GSA Planning

142-150 Narrow Neck Road Katoomba – State Significant Development proposal via the Housing Delivery Authority pathway.

DRAWING SERIES  
**DA6 Design Analysis**  
DRAWING TITLE  
**Height Plane 15.6m\_Roof Plan**

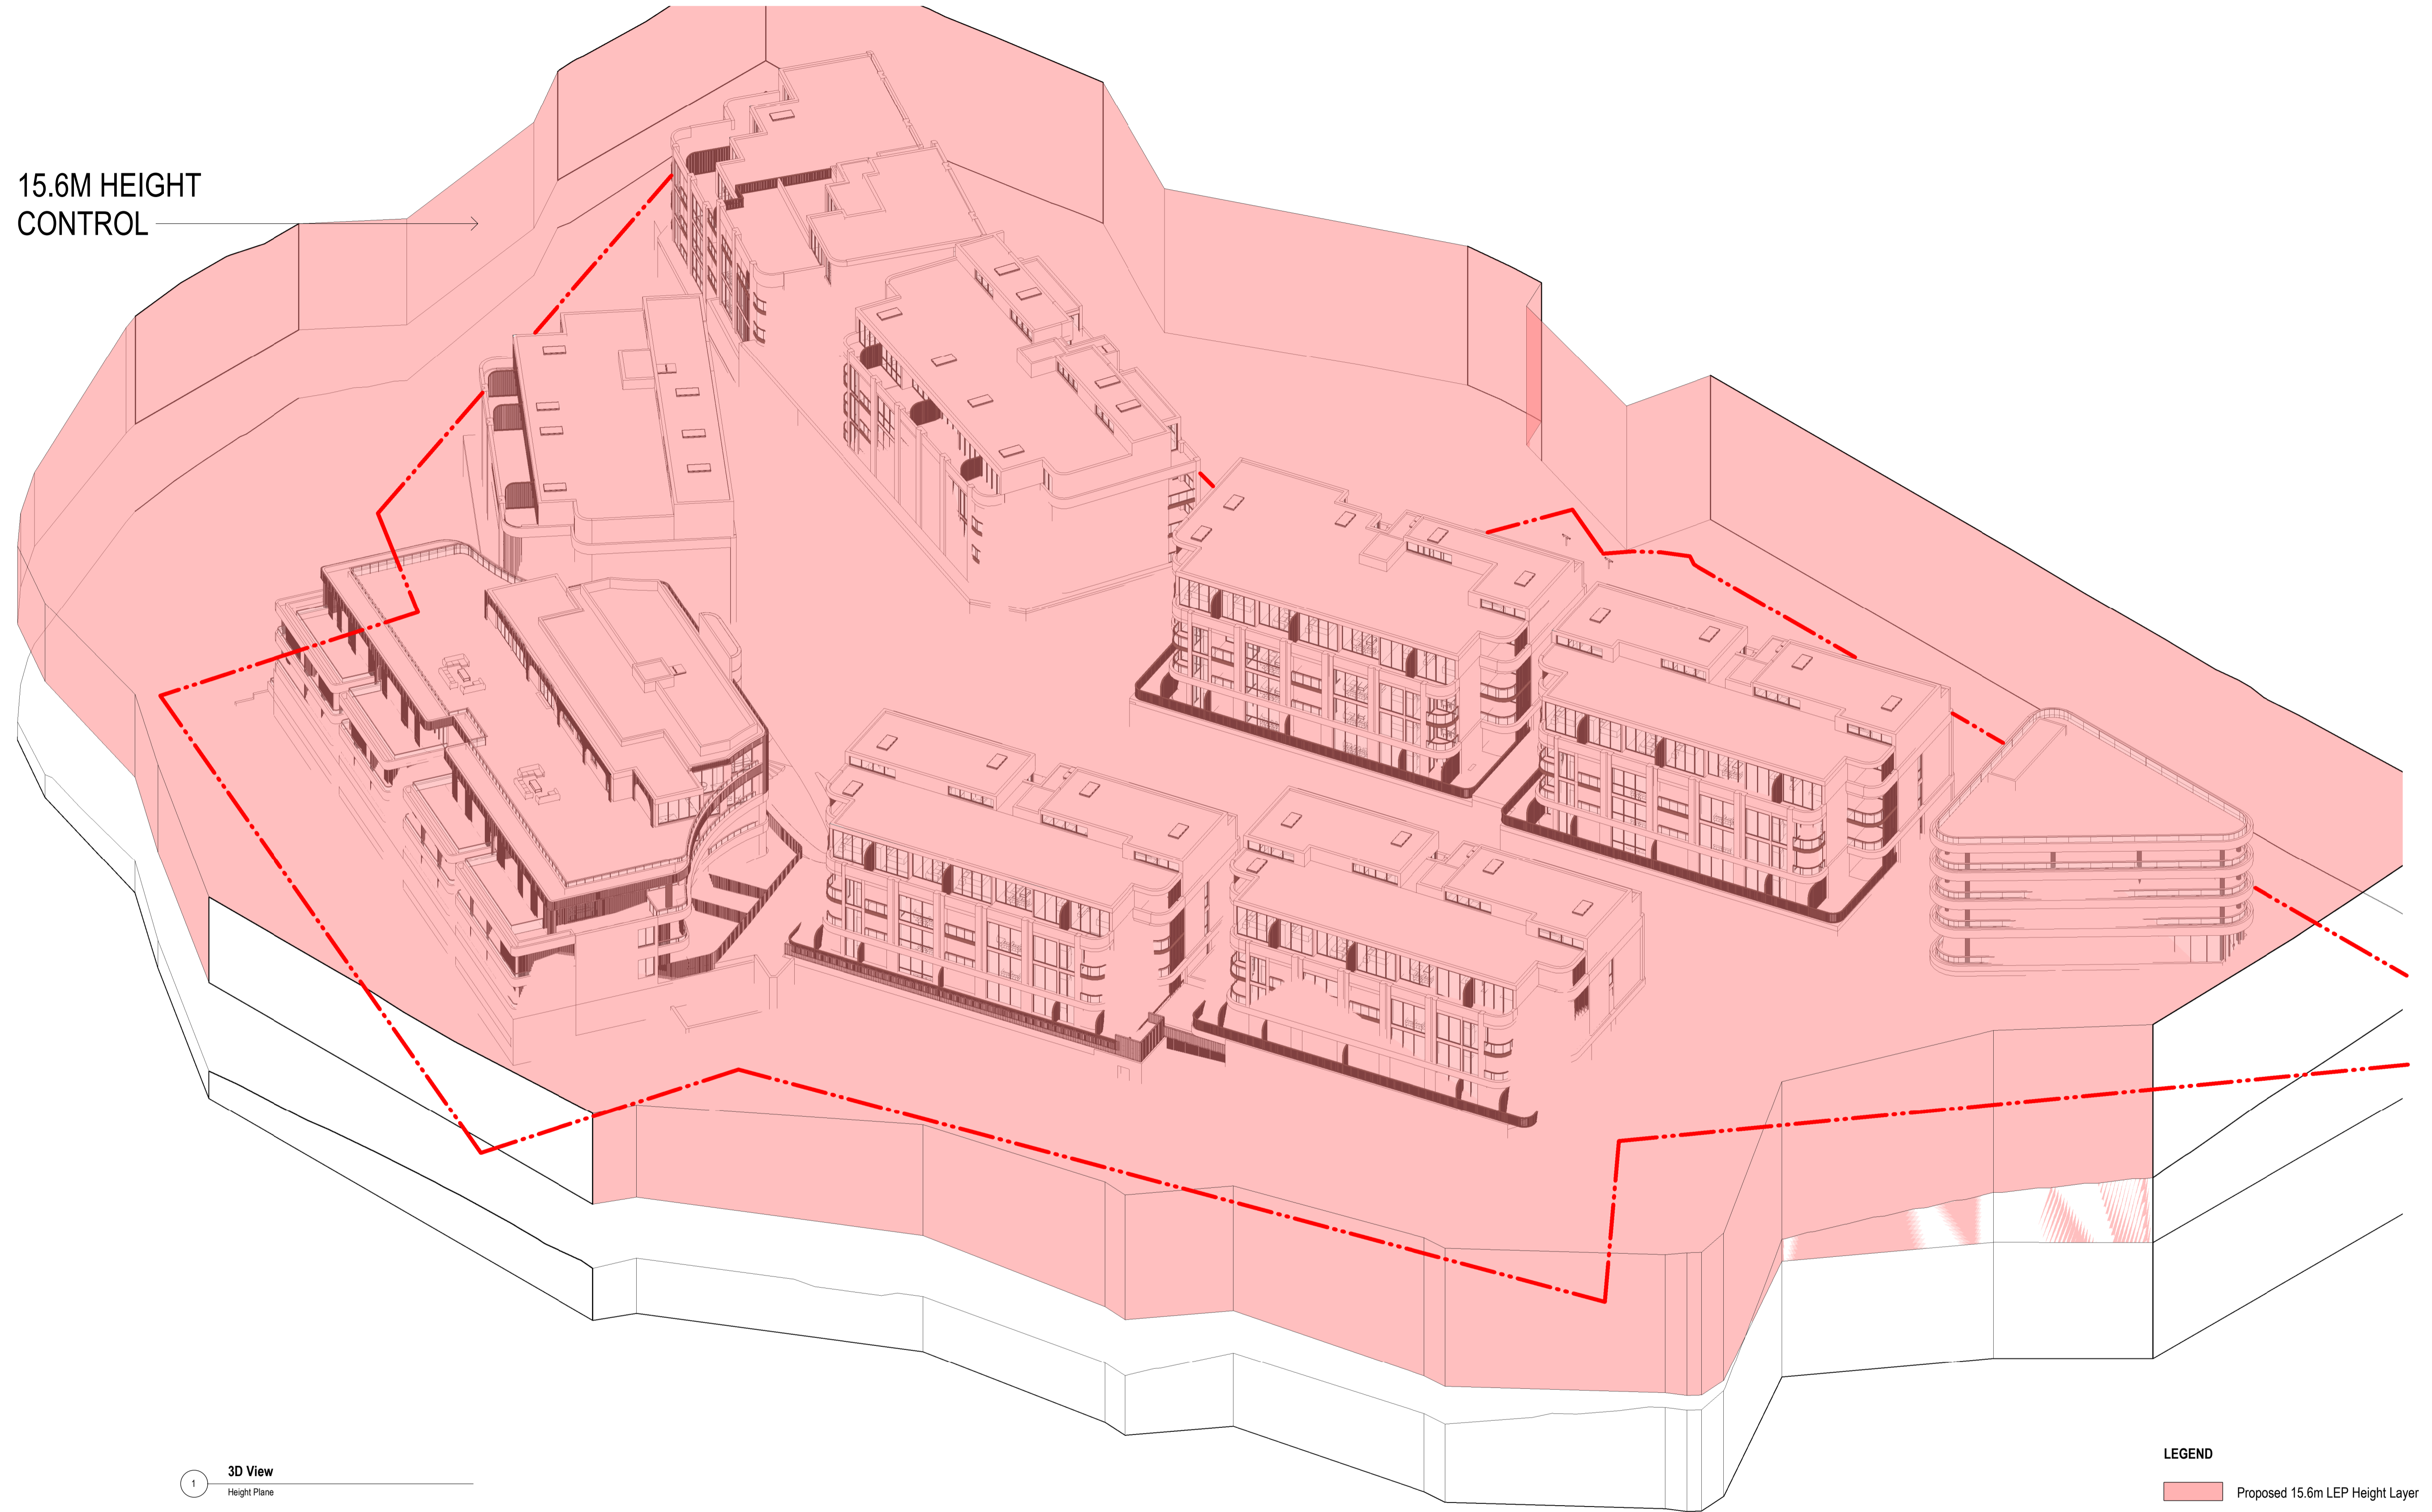
The site is identified on the LEP 2015 Height of Buildings Map Sheet HOB_002G as being subject to a height restriction of 8 metres. The proposal nominates that the whole site (based on drawing DA6.50 Rev B) would be to a height of 15.6m. **The discrepancy between the current control and the proposed development is in the order of 100% across the site**, well beyond the 20% variation nominated in the HDA criteria.

While the submitted document seems to confirm that the variation sought through a concurrent rezoning would be from 10.4m to 15.6m, capturing the bonus available under the Housing SEPP, this is not applicable across the whole site (refer to section 7).
